ASSESSMENT REPORT

Nadine Street Residential Subdivision, Sanctuary Point DA 485-12-2002 MOD 1

PROPOSED RESIDENTIAL SUBDIVISION

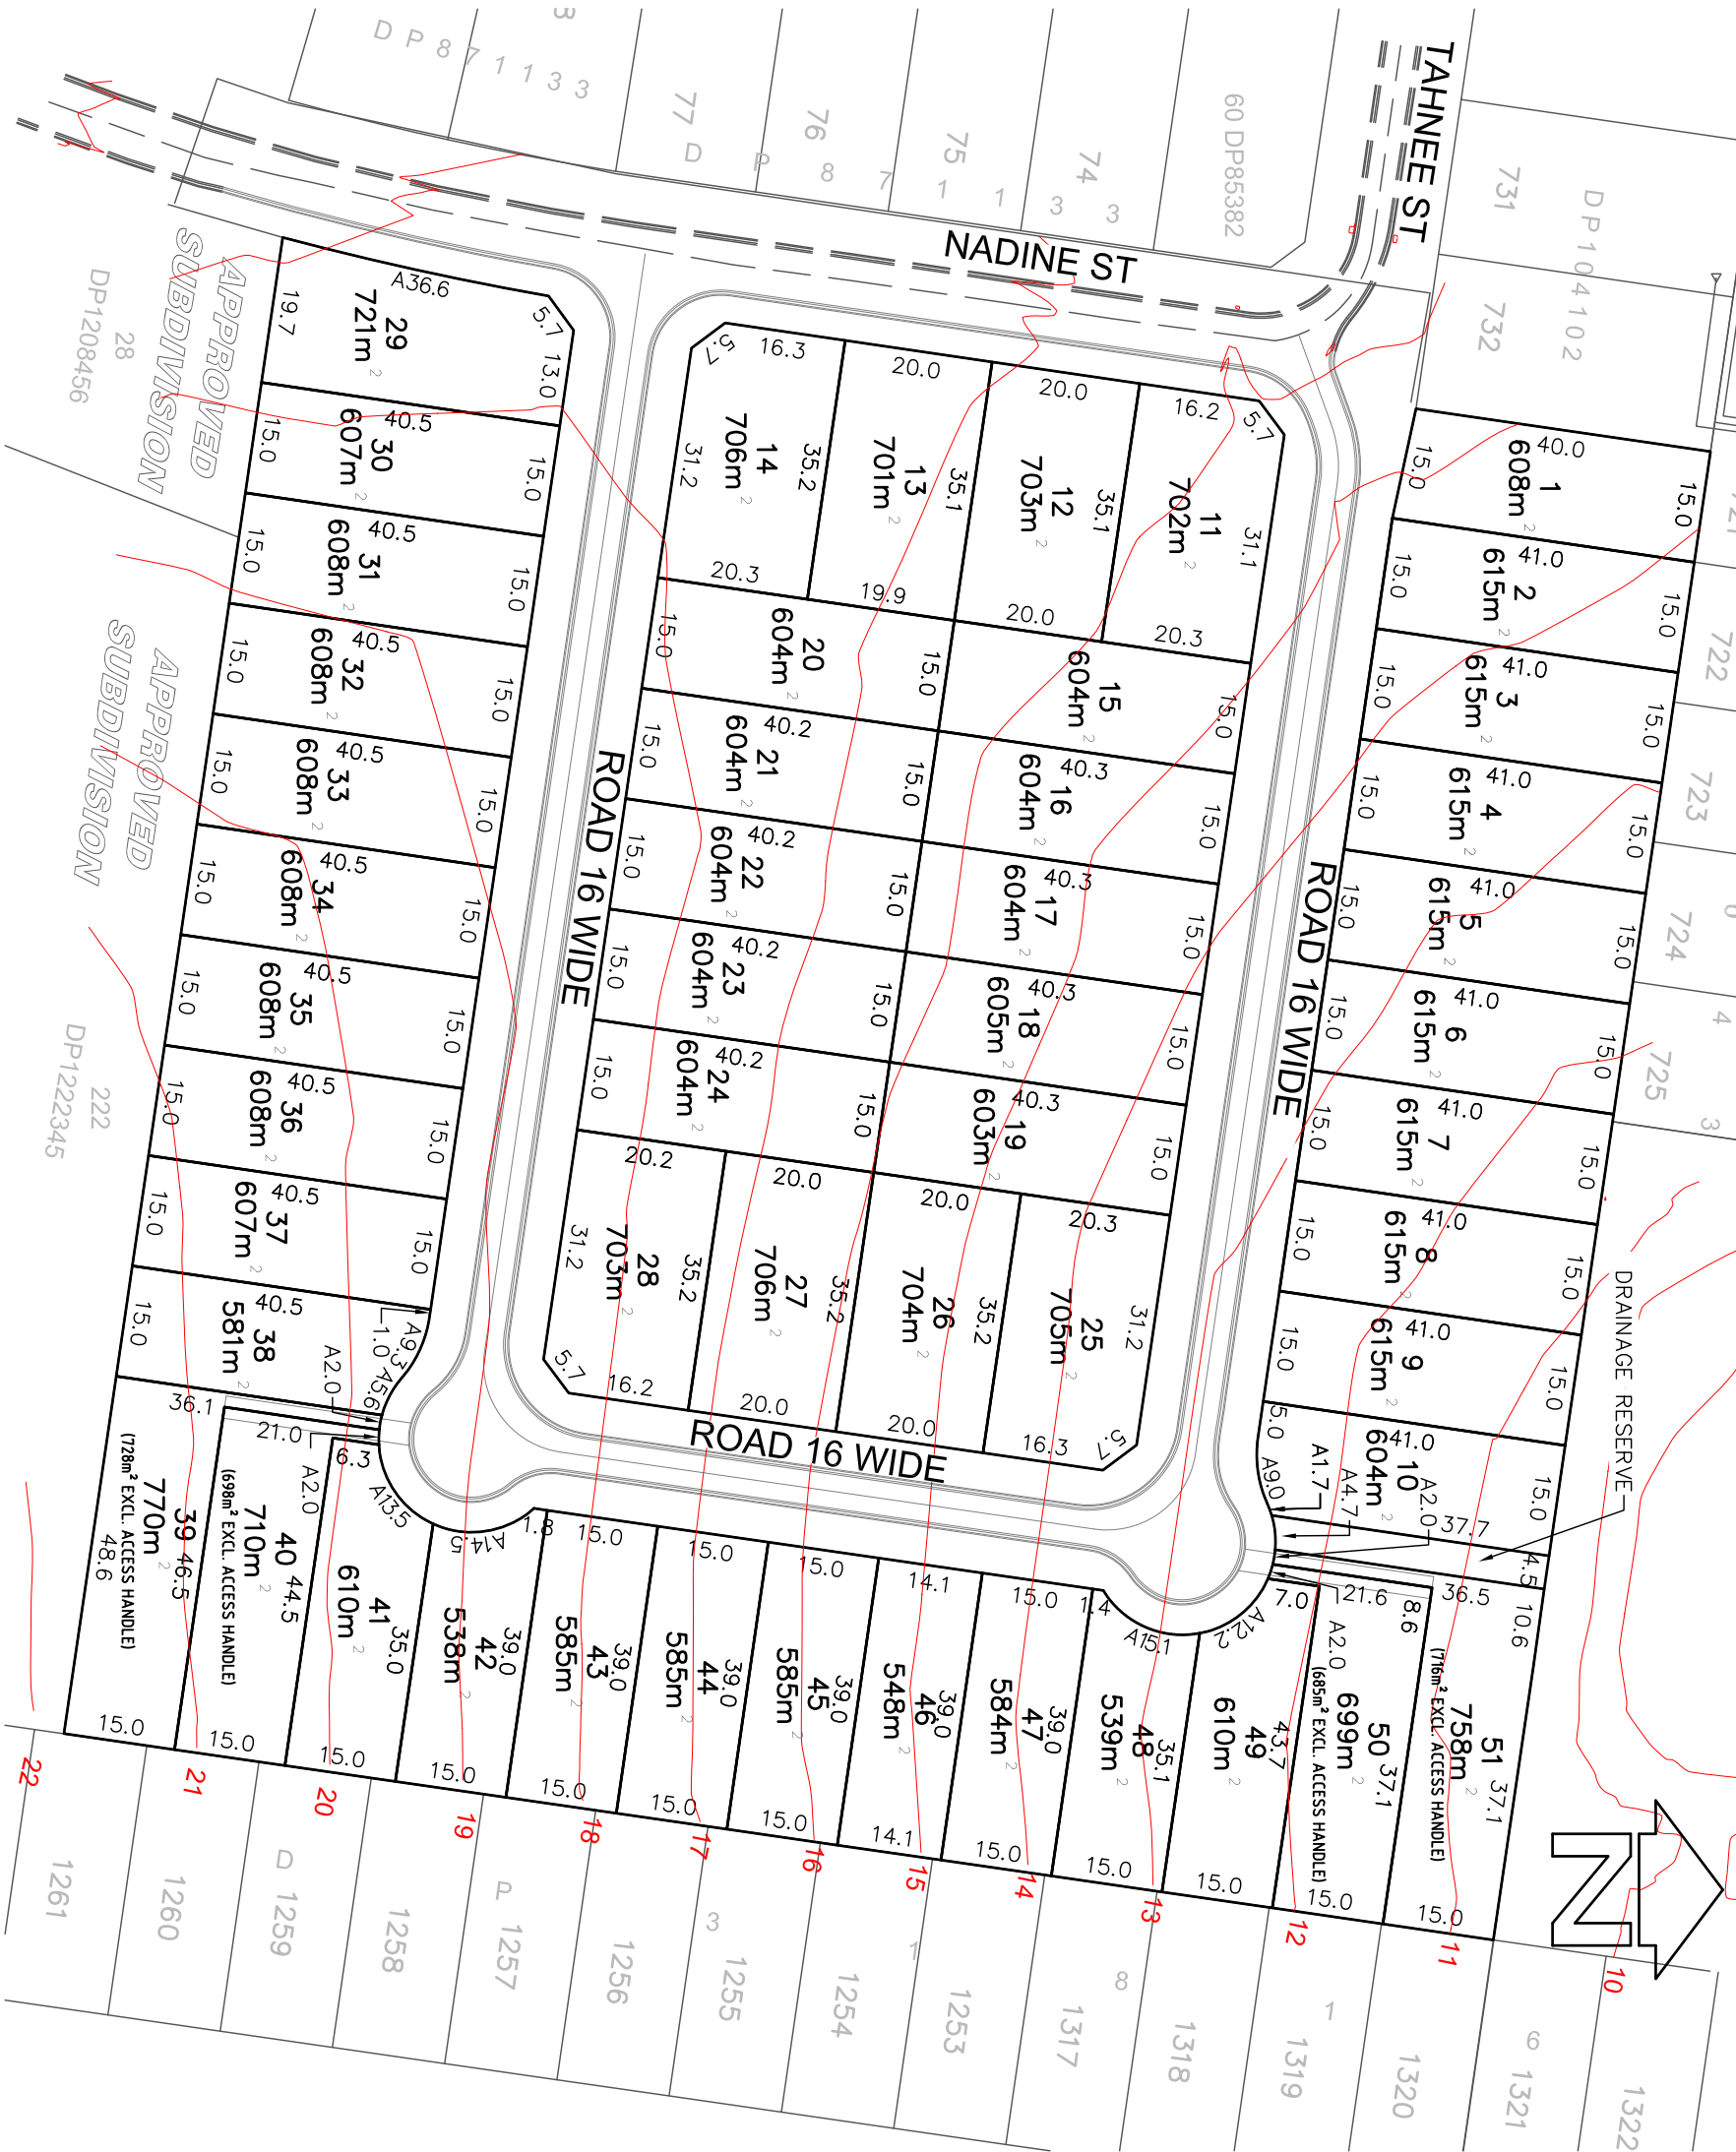
- the increase in lot density and reduced lot widths:
 - o have not been considered with respect to the potential for overshadowing;
 - o are not suited for the retention of trees;
 - o the removal of trees identified for retention has not been assessed;
- battle-axe Lots 39, 40, 50 and 51 have an unacceptable orientation, widths, buildable area size and corner splays;
- the reduction in road widths from 18 m to 16 m is not supported;
- insufficient information has been provided to justify the deletion of the OSD basin; and
- given the time since the original approval (14 years), the removal of on-site vegetation should be subject to a further review of significance.

- the 15 m wide east-west oriented lots are too narrow, would result in adverse privacy and overlooking impacts and should be increased to 16 m in accordance with SDCP 2014;
- road reserve widths should be increased to 18 m, and, the proposed new road would be classified as a Local Street, not an Access Street under SDCP 2014;
- the creation of two large lots (consolidation of battle-axe lots) creates the expectation that medium density housing development can be accommodated on those sites, so those large lots should be further subdivided;
- the land has been cleared and the impact of the development on remaining vegetation must be assessed, as no further information has been provided regarding vegetation; and
- Council agrees to deletion of the detention basin from the site and notes upgrading works within the existing adjacent detention basin would be required.

Issue	Consideration	Recommendation
<i>East-west oriented lots</i>	- The original DA allowed for the creation of residential lots with a minimum width of 18 m. The proposal seeks to reduce the minimum lot width by 3 m, to 15 m (Figures 3 and 4). - Public submissions raised concern that the lots are too narrow and may result in privacy impacts if two-storey dwellings are erected. - Council raised concern that the east-west oriented lots, located along the eastern boundary of the subdivision are too narrow and, may result in privacy and overshadowing impacts and should be increased to a minimum width of 16 m in accordance with SDCP 2014. - The Proponent argues the proposed 15 m wide residential lots are acceptable, as: - lots with 15 m widths are not uncommon within the Shoalhaven LGA and Council has recently approved 15 m wide residential lots in other locations; and - the east-west lots slope north and therefore can accommodate single and two-storey dwellings without adverse overshadowing impacts. - The Department notes SDCP 2014 stipulates rectangular lots should not be narrower than 16 m and allow for a 15 m x 15 m building envelope. - With regard to the north-south oriented lots, the Department considers that despite the SDCP 2014 provisions, a 15 m lot width is acceptable as these lots would gain good levels of solar access and can be designed to minimise privacy impacts. The Department also notes Council raised no concern with the width of these lots. - The Department agrees with Council that the east-west orientated lots should be increased in width by 1 m to comply with SDCP 2014 minimum (16 m) to ensure future dwellings achieve appropriate levels of amenity, in terms of solar access and privacy. - The Department notes this increase could reasonably be accommodated by a minor reduction in the width of the large corner lots. The Department recommends a condition accordingly.	The Department has recommended a new condition B10 (a) requiring the east-west oriented lots be increased to 16 m in width.

- consolidation of battle-axe Lots 39, 40 and 41 into one lot (Lot 39) and Lots 49, 50 and 51 into one lot (Lot 47), resulting in the reduction of proposed new lots from 51 to 47 lots;
- confirmation of trees for retention;
- amended road design to accommodate emergency service vehicles and garbage trucks; and
- increased width of Lot 44 (previously Lot 46) from 14.1 m to 15 m.
